Application no: H23/0186/01
Original Applicant: A M Woods
Washway Road
Saracens Head
Spalding
Lincs

Description: Residential development (3 dwellings)

Amendment: Amendments to elevations
Dwg. nos. rem946-02, rem946-03 & rem946-04

**TOWN AND COUNTRY PLANNING ACT 1990
NOTICE OF ACCEPTANCE OF AMENDMENT**

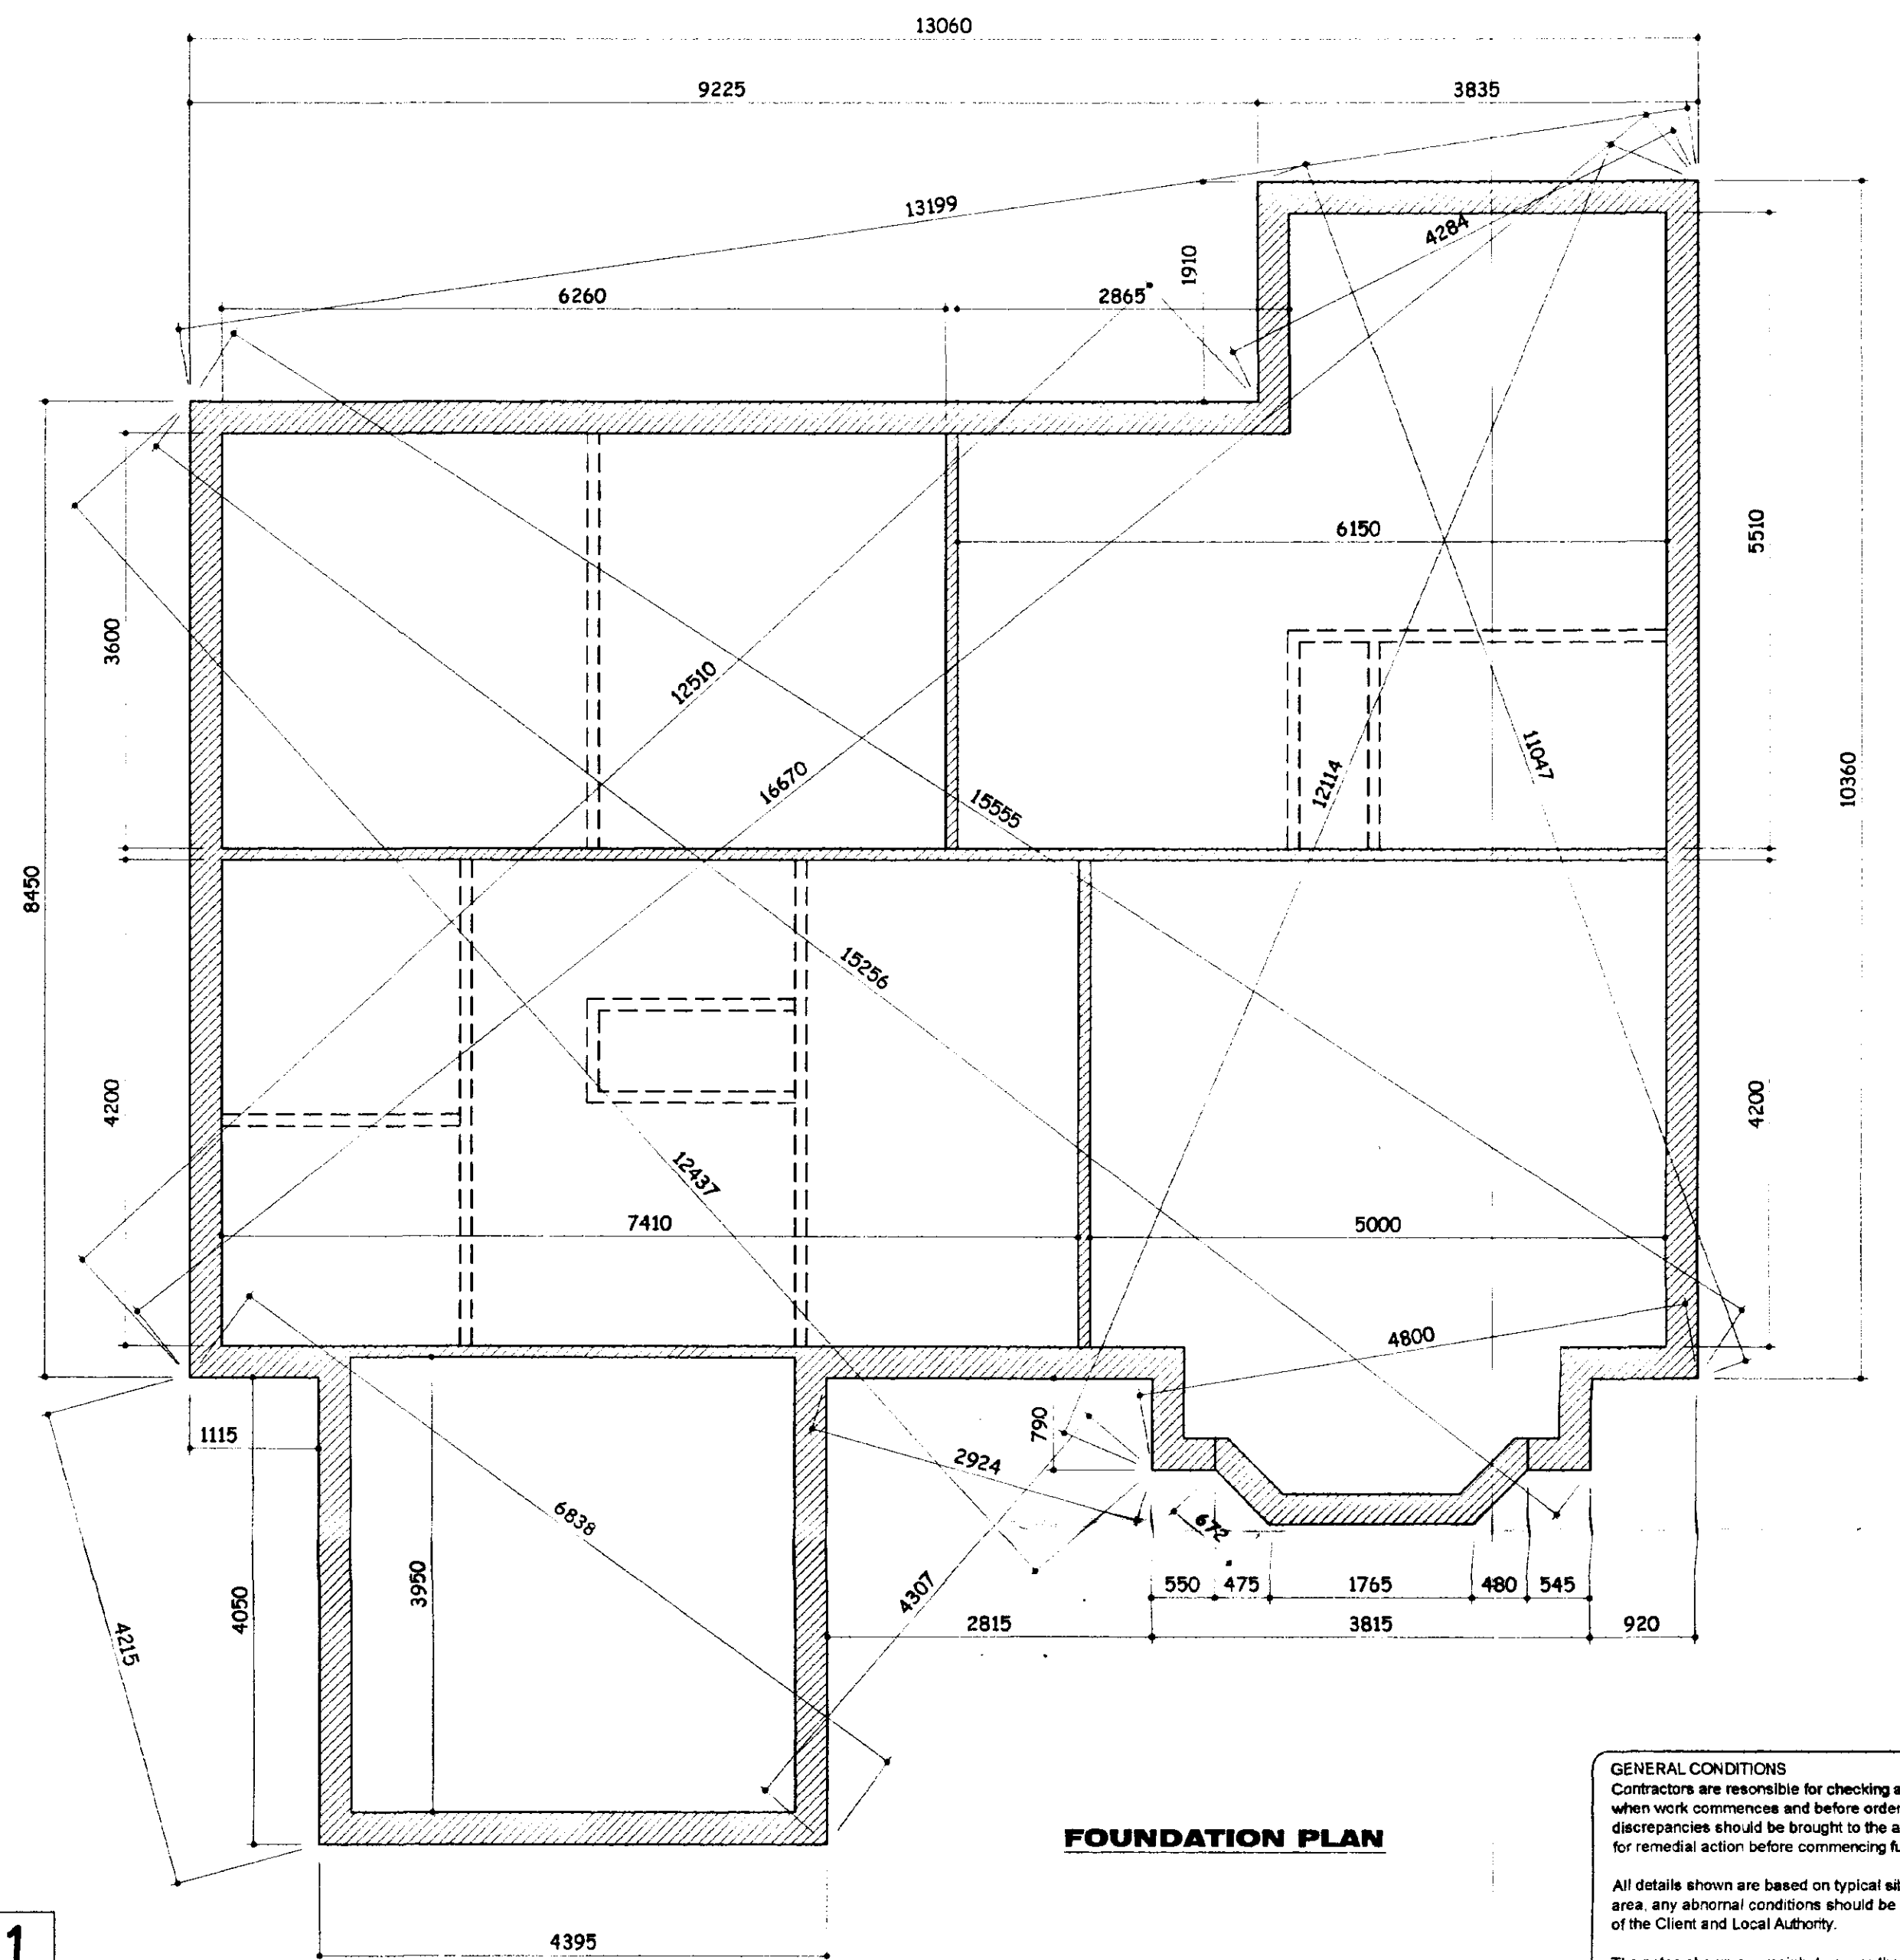
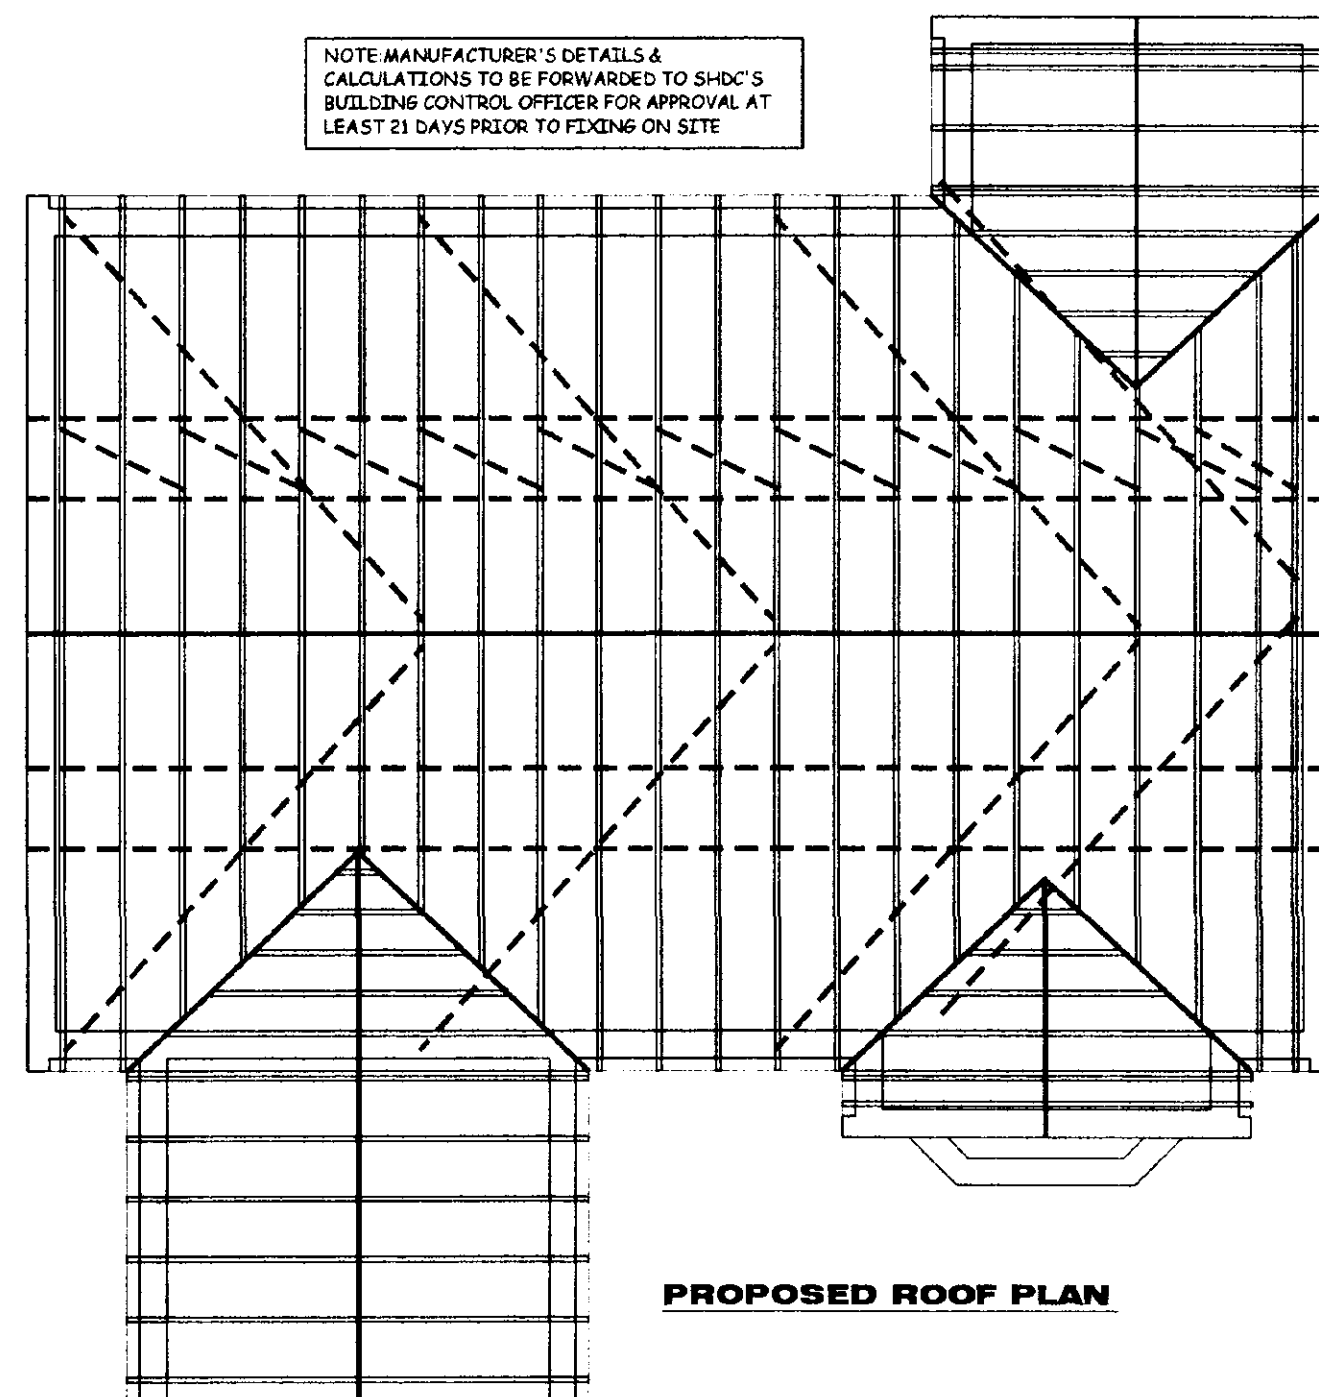
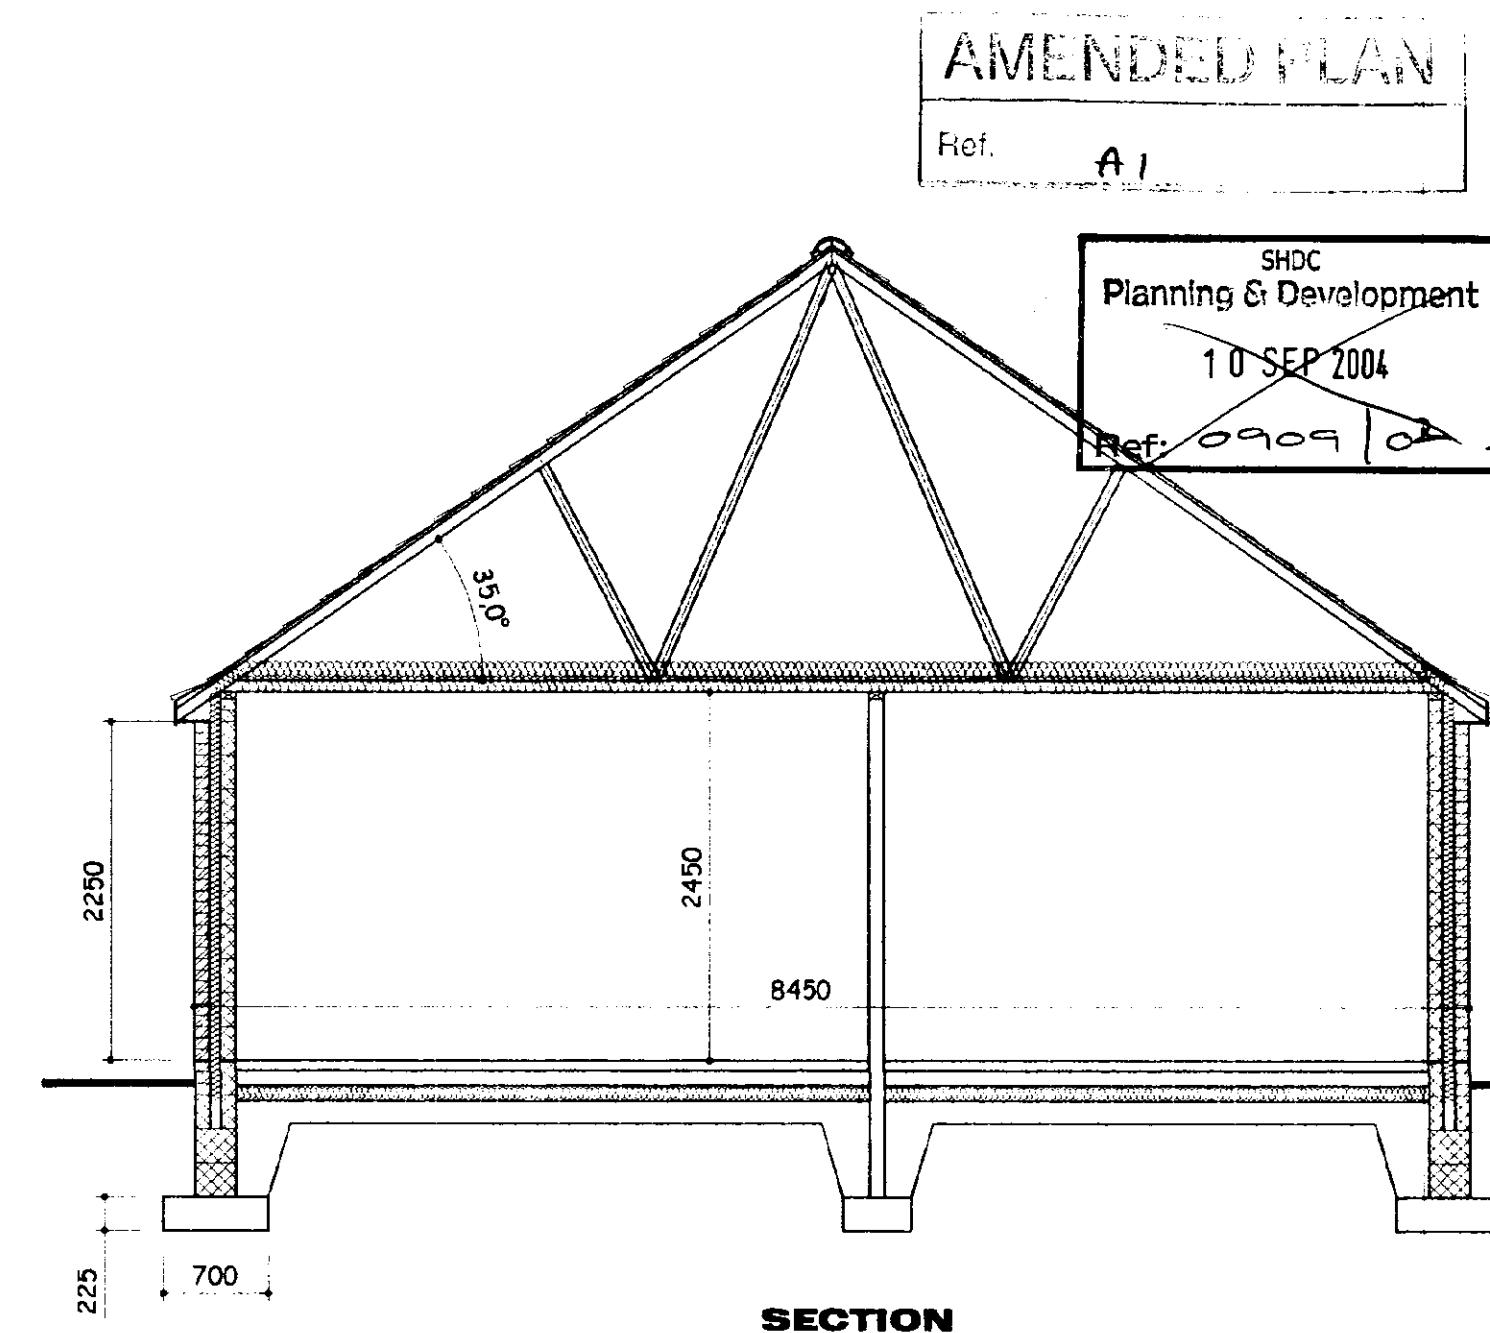
- Feature brickwork plinths have been omitted to all plots
- Feature Parapet Gables have been omitted to all plots
- Removal of all chimneys
- Plot 1 front elevation simplified
